London Luton Airport Expansion

Buckinghamshire Council Response to the Applicant's Response to Deadline 6 Submissions 6

PINS REFERENCE: TR020001

January 2024

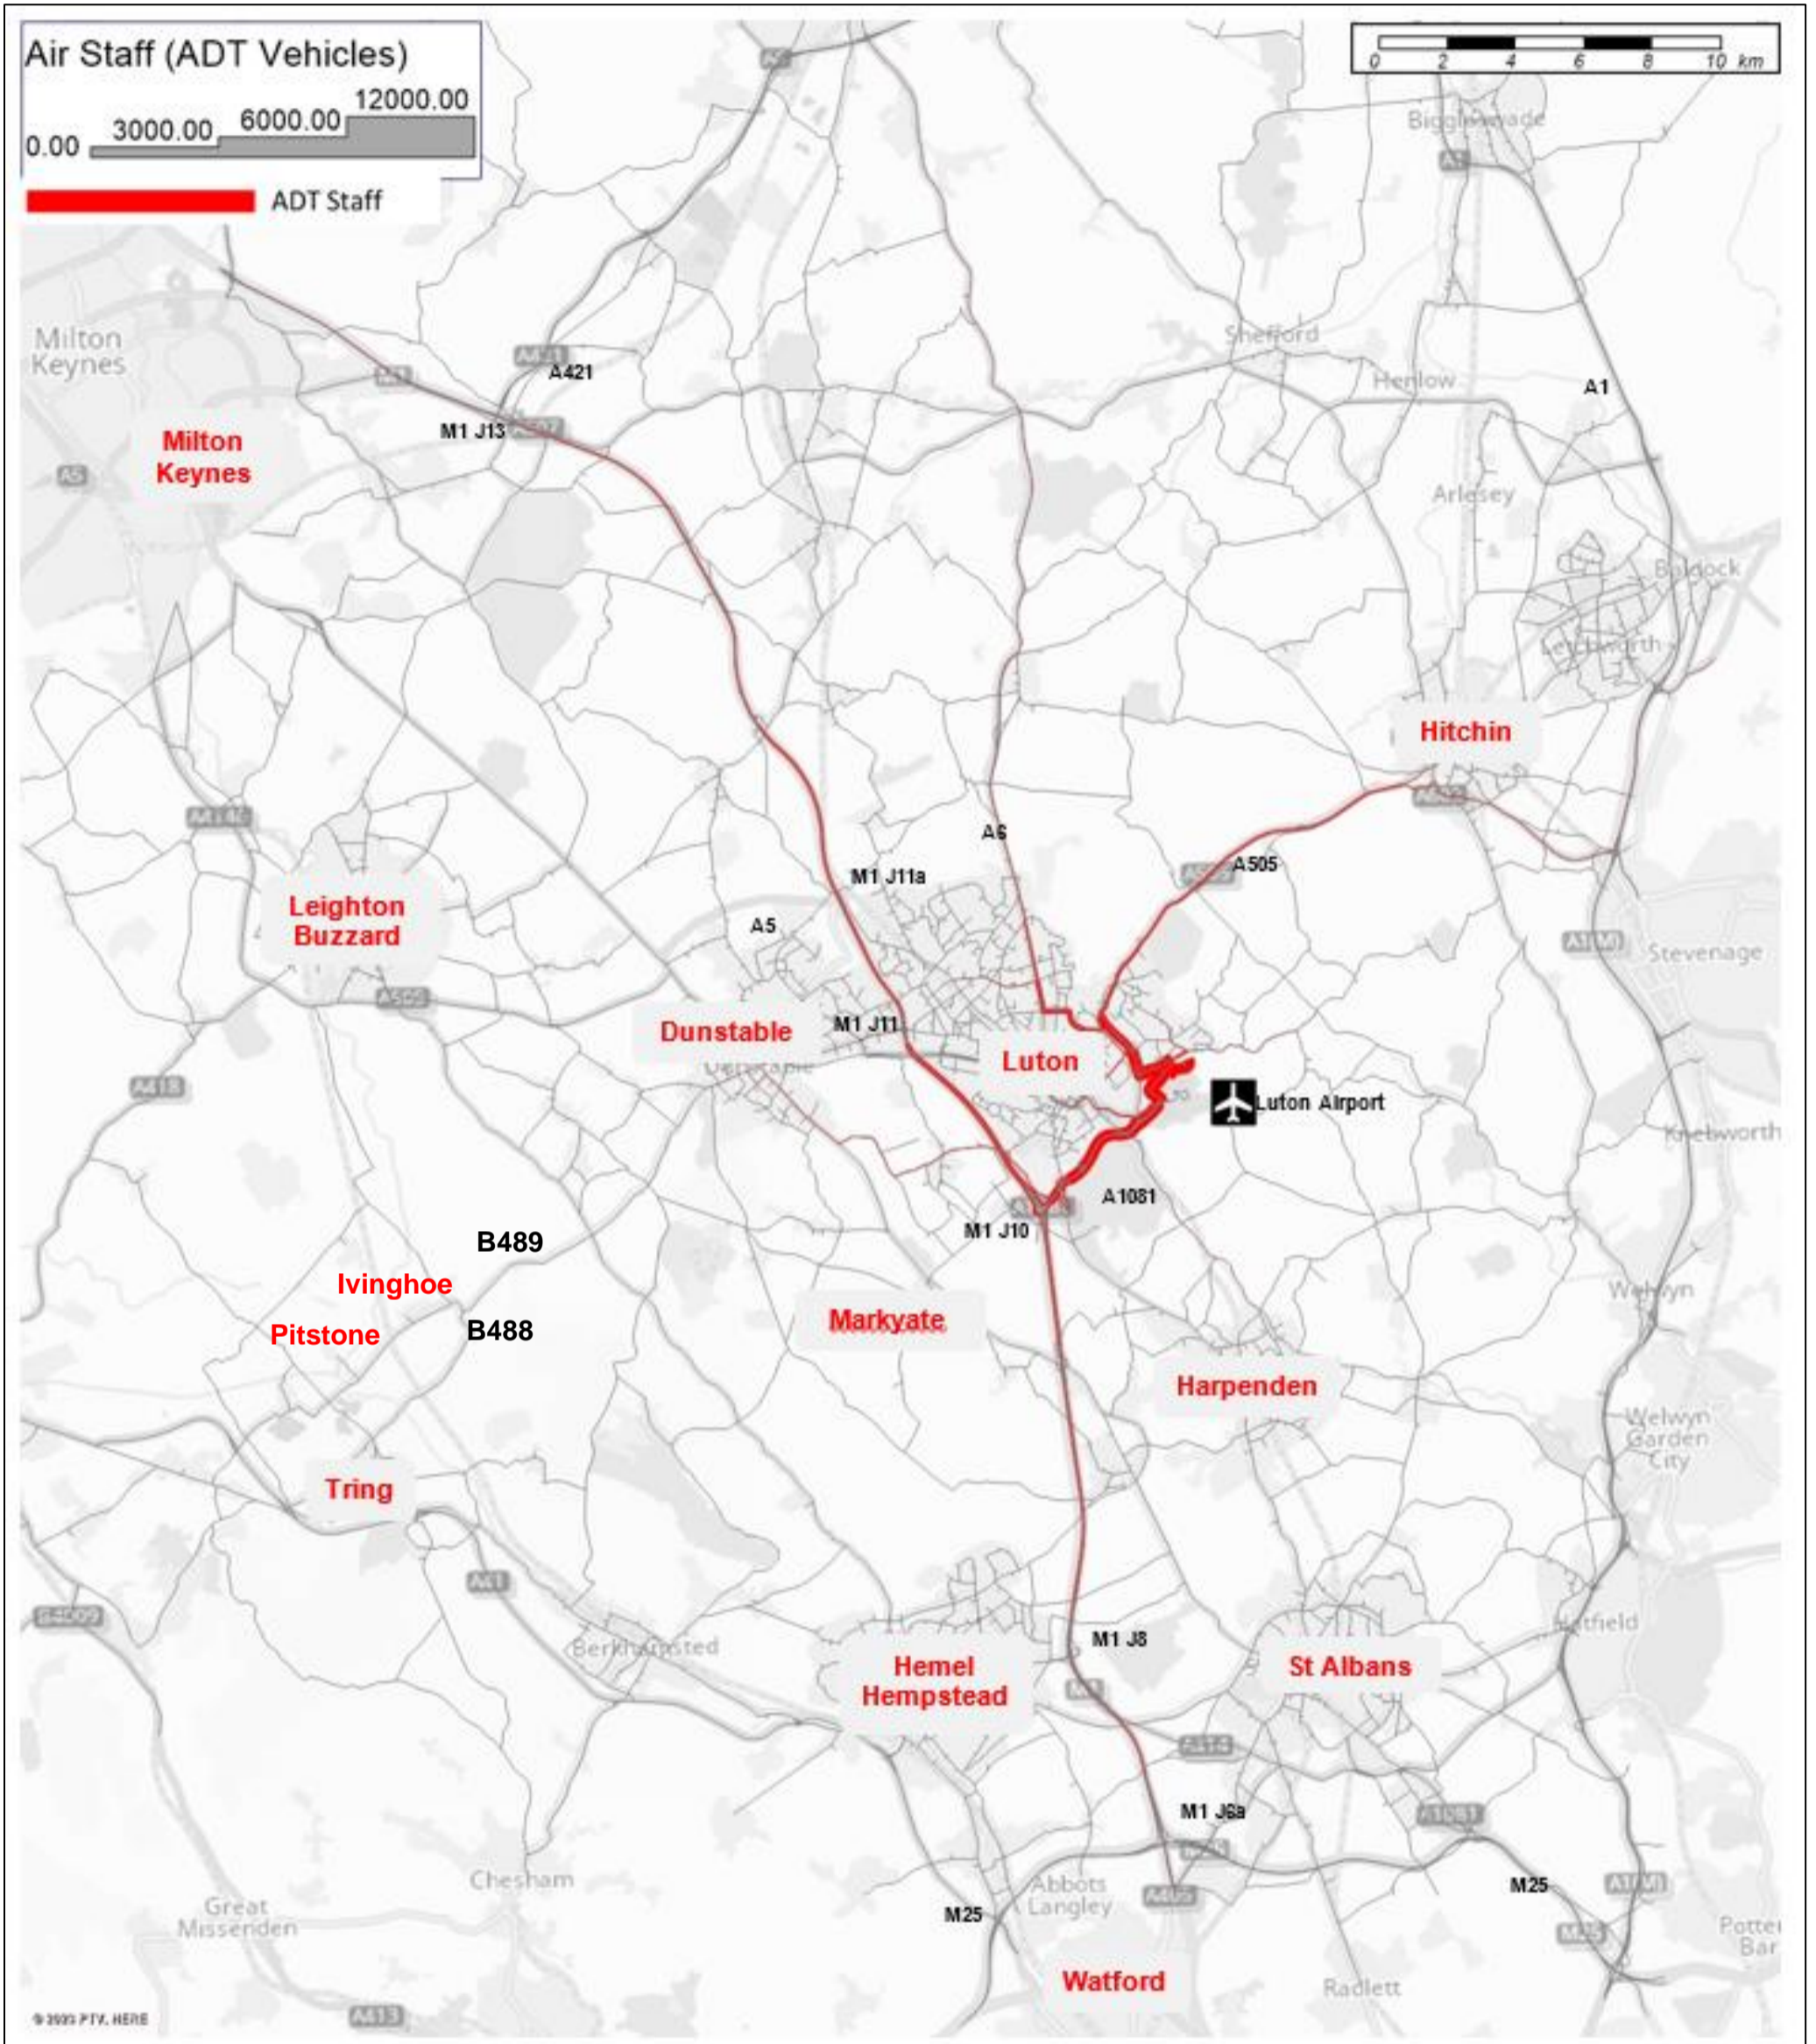
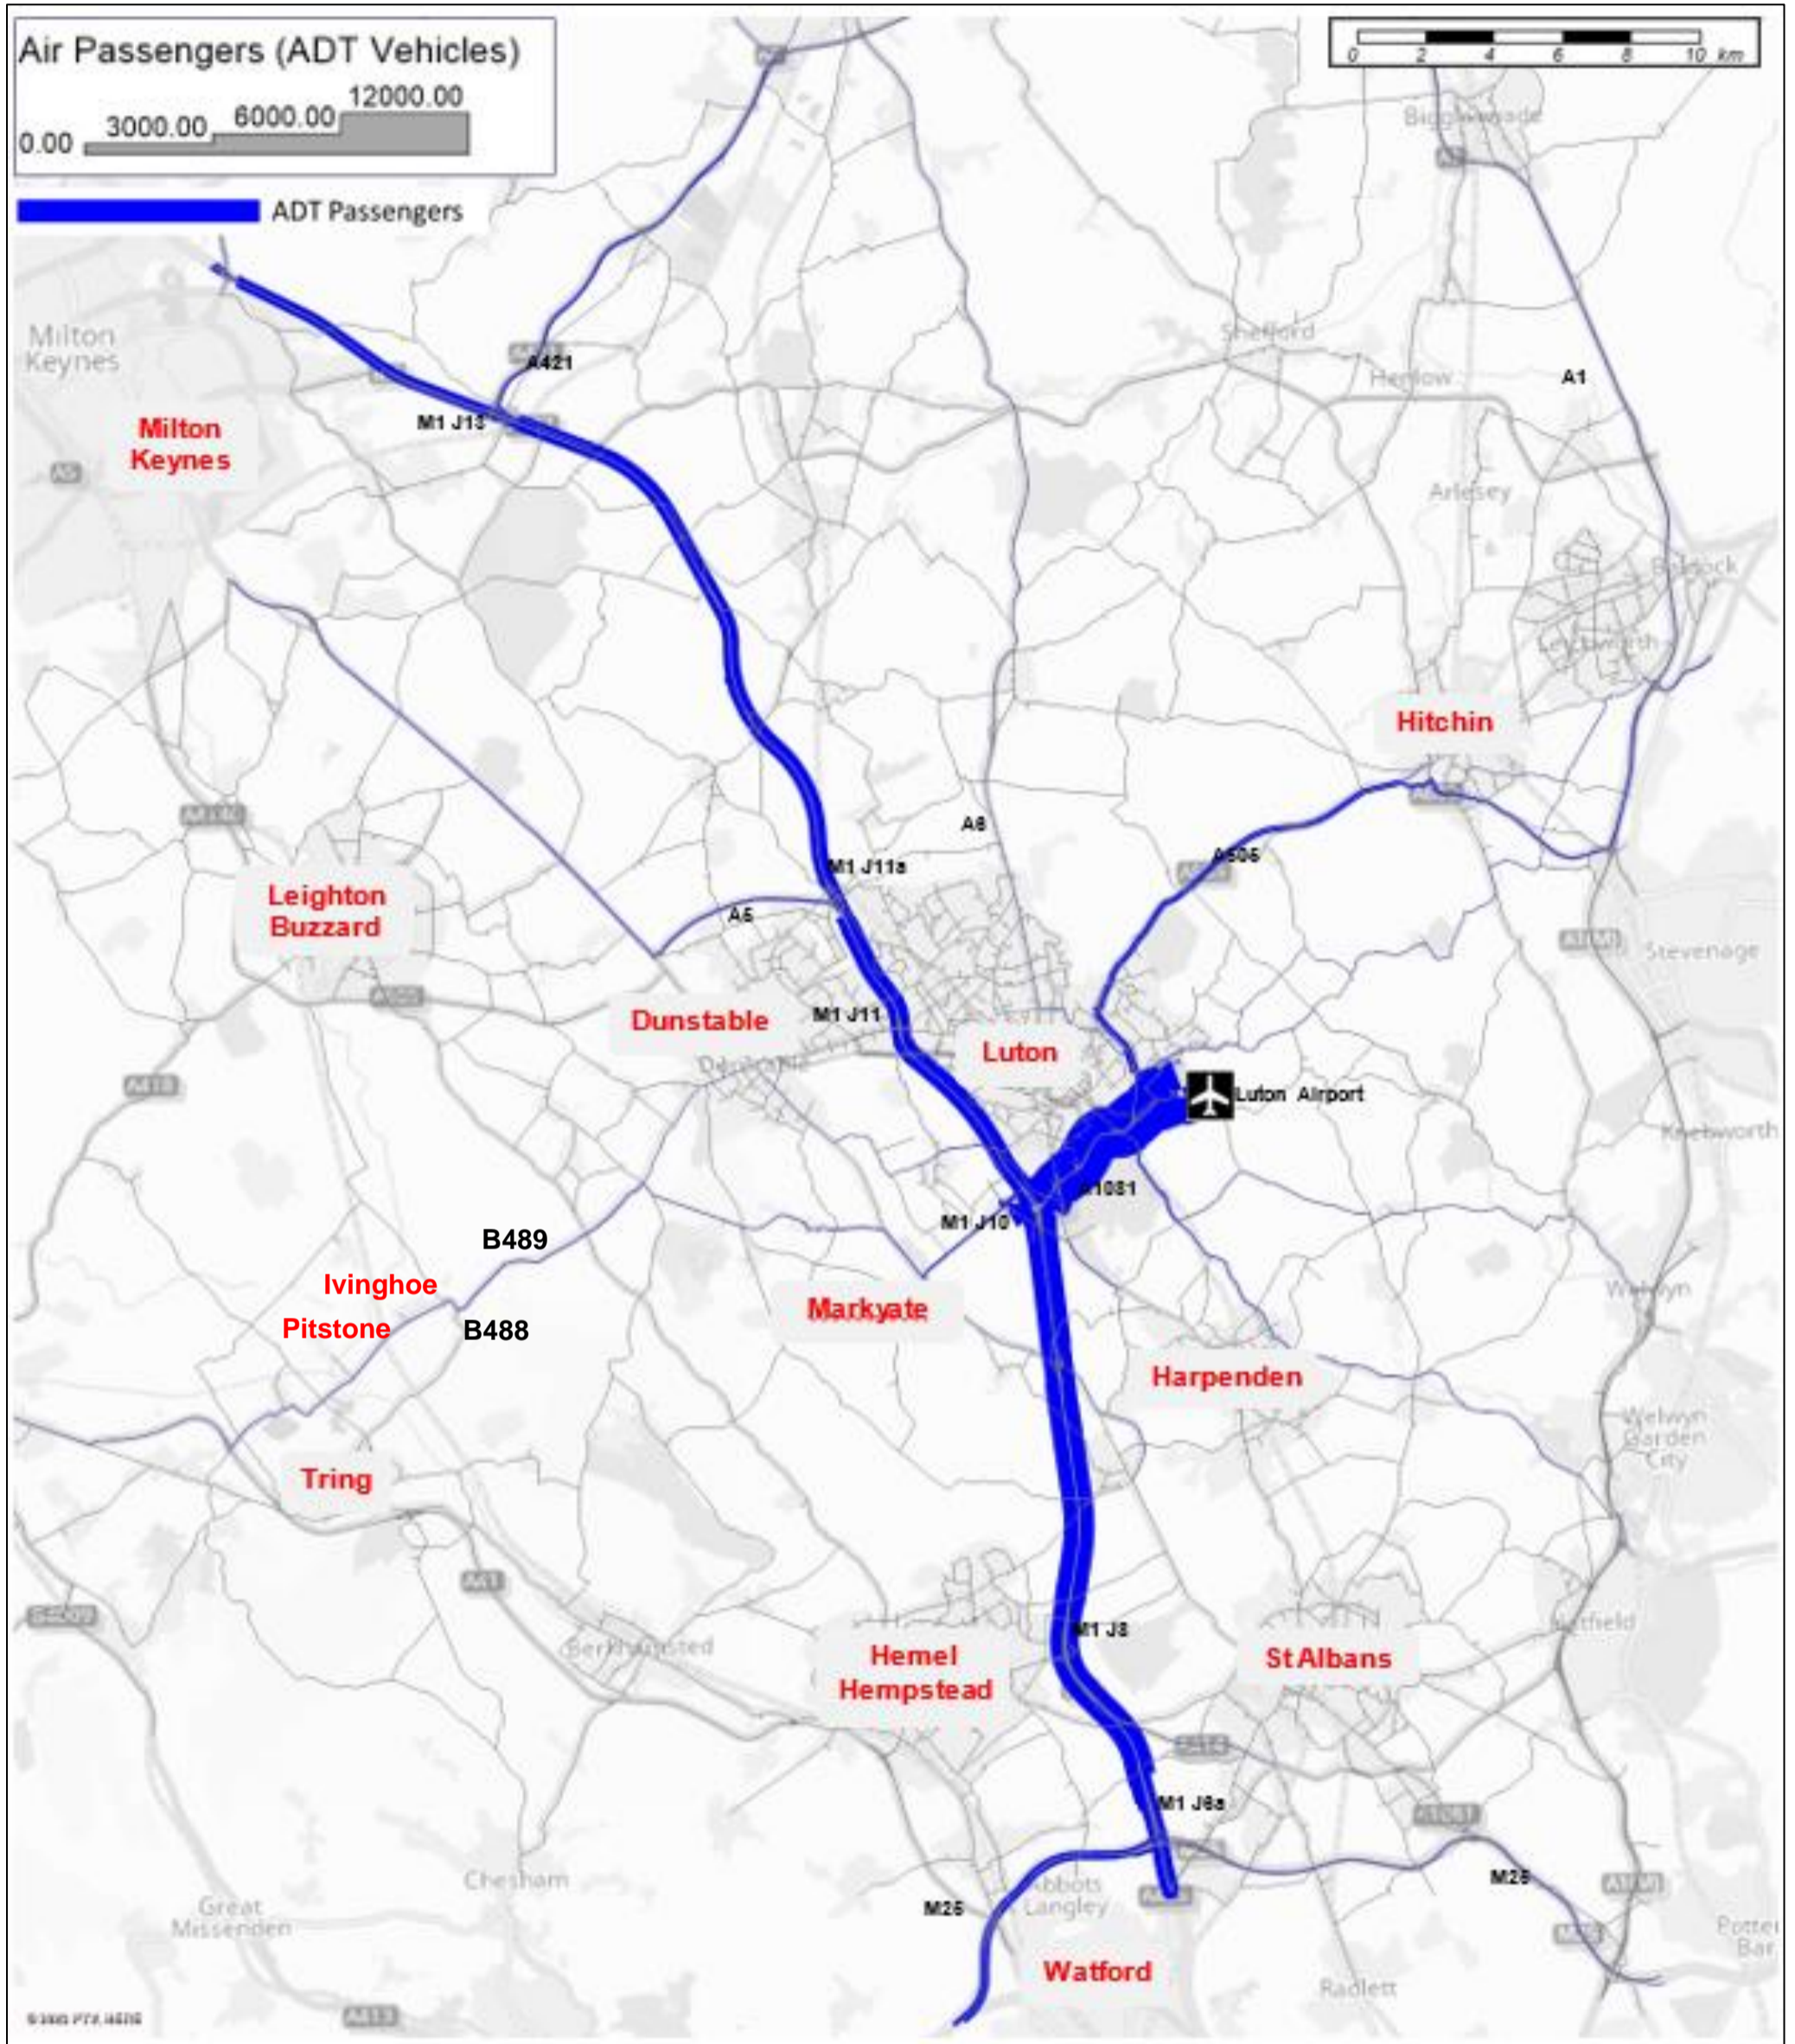
<p>3.4 Surface Access</p>	<p>Ivinghoe junction The Trip Distribution Plans [REP5-037] show that the west east corridor is an important route from the west to the airport. The routes through the villages are not well suited for such usage, which vehicles passing through locations that will be sensitive to relatively small changes in traffic flow, with small increases in vehicle throughput leading to material safety concerns where elements of the route are inherently unsafe.</p> <p>The Trip Distribution Plans [REP5-037] demonstrate that with the expansion of the airport, greater numbers of air passengers shall use this route. This is evidenced by the 3 thickening of the difference plot line but, as stated above, the numerical data has not been supplied to quantify this impact.</p> <p>As noted by the ExA during the hearing, the model routes the traffic through the Bucks villages (Pitstone, Marsworth and Ivinghoe). That modelled prediction, despite the lack of suitability of that route in highways safety and environmental terms, justifies the relatively minor works BC proposes to the Ivinghoe junction in order to re-route traffic down the more suitable B488.</p> <p>Such changes to the priority junction at the B489 and B488 Ivinghoe would reduce traffic using unsuitable routes, protecting pedestrian and driver safety within the villages and making the main route away from the villages improves air quality within the villages. BC maintains until demonstrated otherwise that the junction priority works at the B488/ B489 junction should be included within the required works for the scheme and not left to the Council to fund at a later date, either through the</p>	<p>As mentioned in the response provided at ID 3.3 above, the Applicant acknowledges that some forecast airport trips would be travelling along the B489. However, the Applicant's view is that the forecast increase in traffic is not considered 'severe'.</p> <p>Detailed information on the forecast numerical change in traffic along the B489 is included in Applicant's Response to Issue Specific Hearing 7 Action 3 - Ivinghoe Junction Modelling Review [REP6-070]. Further numerical information is also included in relation to the Rule 9 modelling update which is reported in the Applicant's Response to Issue Specific Hearing 7 Action 2 - Accounting for Covid-19 in Transport Modelling Final Report [AS-159].</p> <p>Moreover, the Applicant discussed in the Applicant's Response to Issue Specific Hearing 7 Action 3 - Ivinghoe Junction Modelling Review [REP6-070] the pre-existing issues along the B489 and its junction with the B488. The Applicant has not yet seen evidence to support the issues referred to, and whether they are related to capacity, safety, or health (related to early hour traffic), and more importantly how a relatively small increase can lead to material concerns.</p> <p>The Applicant also notes that the proposal to re-prioritise the B489/B488 junction could potentially divert traffic onto the B488 and Tring, within the Hertfordshire road network without consultation with that highway authority that the Applicant is aware of.</p>	<p>As above, in addition, BC is aware that movement of traffic to the B488 would lead to traffic travelling through Tring. It is however the Council's position that this is currently the official signed route and properties on the B488 are set back from the carriageway with gardens and hedges. The B489 has properties abutting the carriageway with no buffer to residents being impacted by noise or increased traffic impacts. It therefore remains the Council's position that increases in traffic should be kept by all practical means on the signed route and not through the villages on the B489.</p>
